Portishead Branch Line (MetroWest Phase 1)

TR040011

9.33 ExA.WQ2R.D5.V1 – Applicant's responses to the Examining Authority's
Written Questions ExQ2

Responses to ExA Questions
Applicant's Responses to the Examining Authority's EXQ2 Round of Written Questions

NOTES

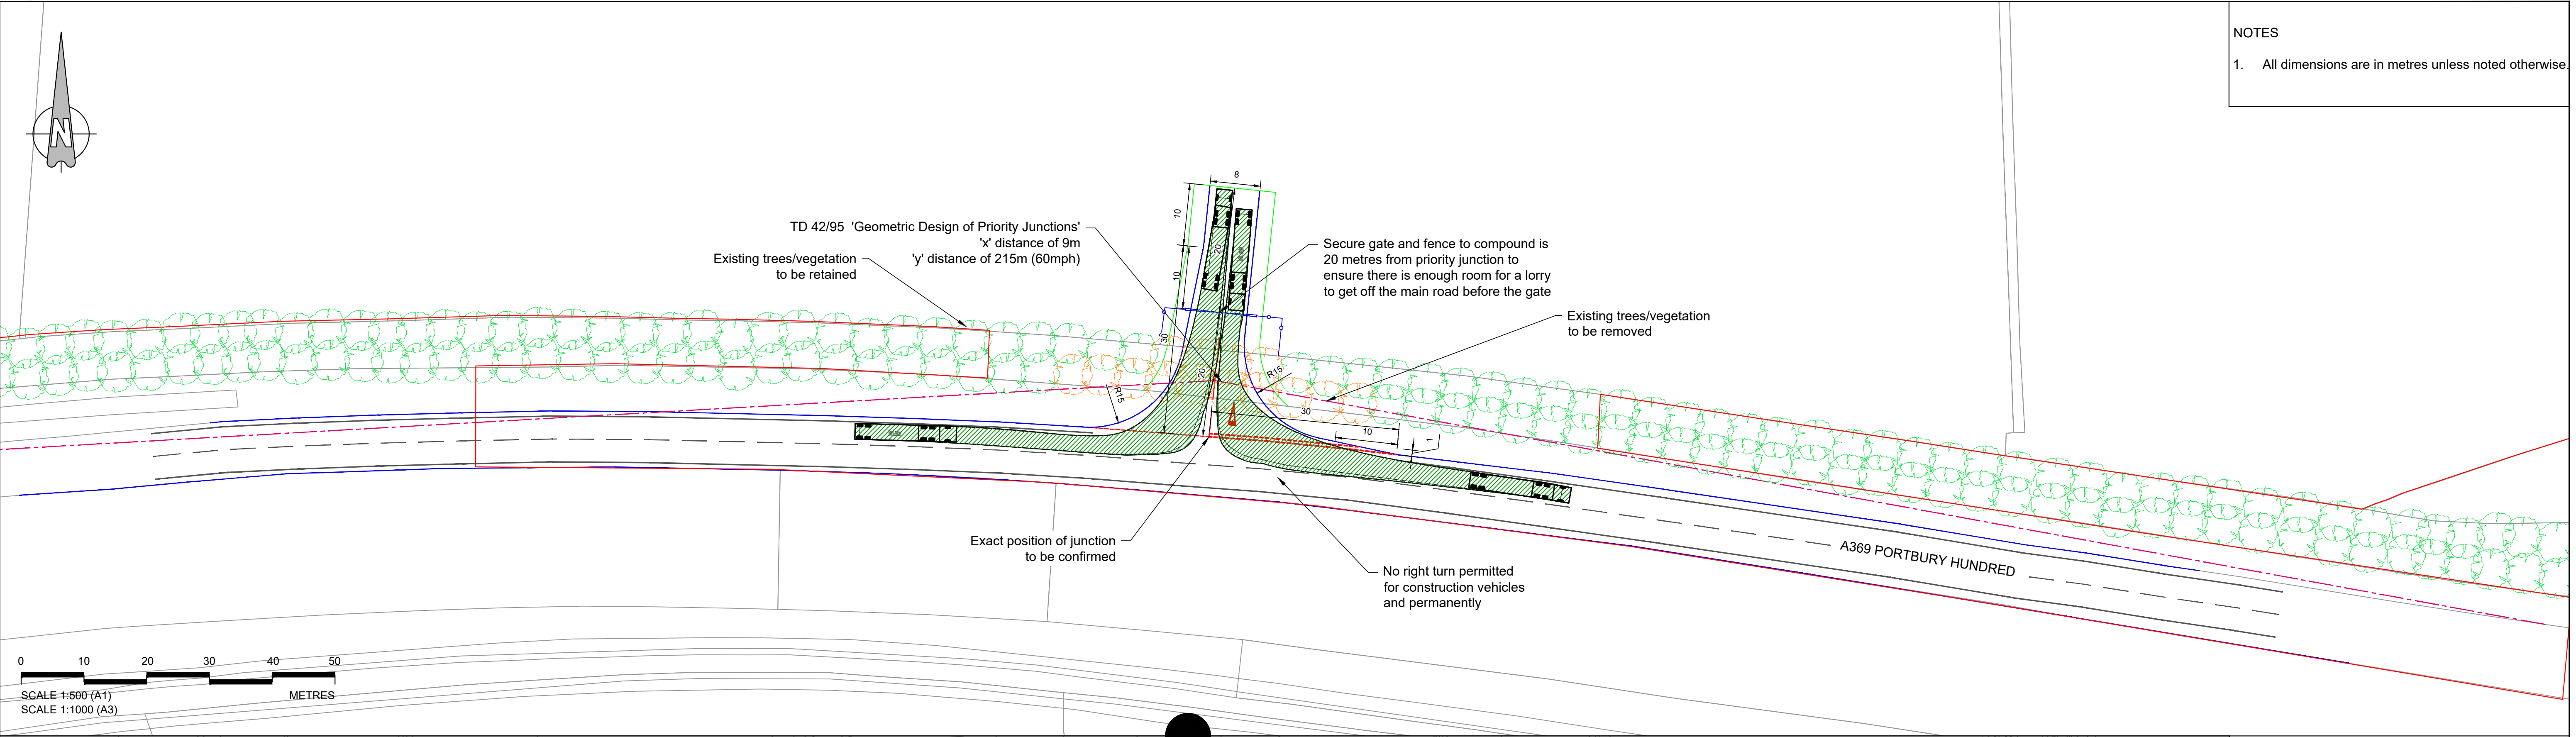
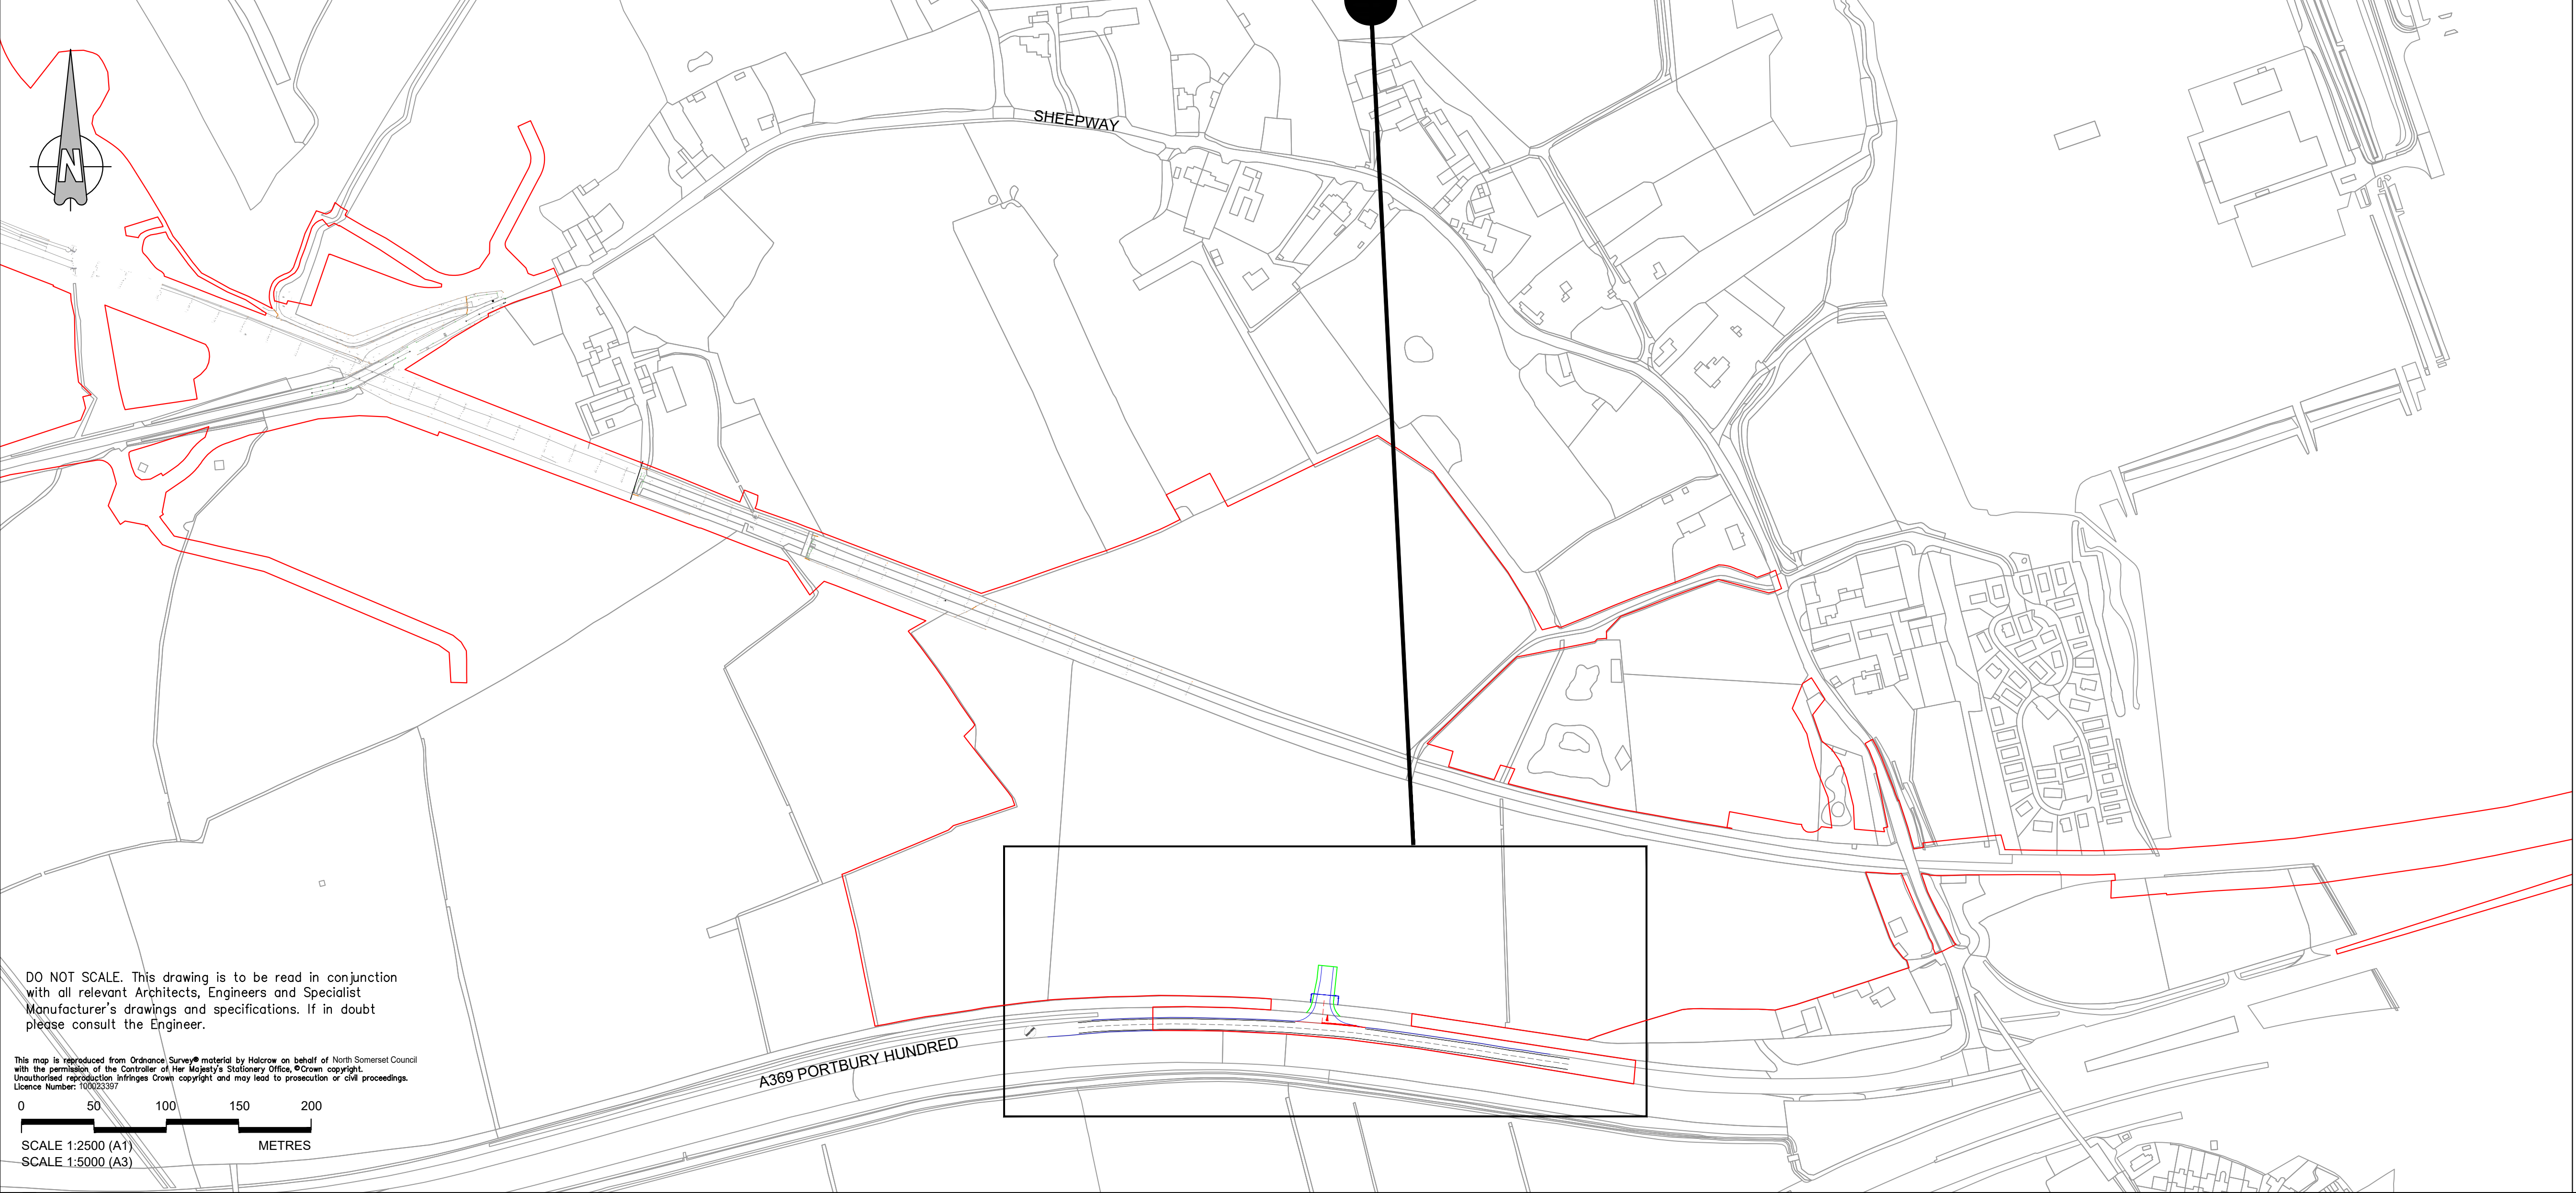
| ExQ2 | Question to: | Question | Current response |
|--------|---|--|---|
| CI.2.2 | <p><i>Access at Portbury Hundred</i> The Applicant</p> | <p>Permanent access into Portbury Hundred following use of land as a temporary construction compound is required as an alternative farm access following closure of a crossing. However, the scale of the junction</p> | <p>i) The A369 Portbury Hundred is a relatively high-speed road and has been designed to allow vehicles to leave the highway completely before stopping at the gate, and with sufficient space so that they do not cross onto the opposite side of the carriageway. Similarly,</p> |

| ExQ2 | Question to: | Question | Current response |
|--------|--|---|---|
| | | |  <p data-bbox="1308 651 2114 754">The access arrangement has been agreed with NSC Highways for the planned uses (during construction and farm access).</p> <p data-bbox="1308 799 2114 1086">ii) The junction will form the sole access for the landowner. A gate will be installed to prevent public access onto the landowner's land. There are a large number of similar agricultural access throughout North Somerset. As with these similar accesses should anyone other than the landowner block the access, then the landowner or the NSC Highways should contact the Police.</p> |
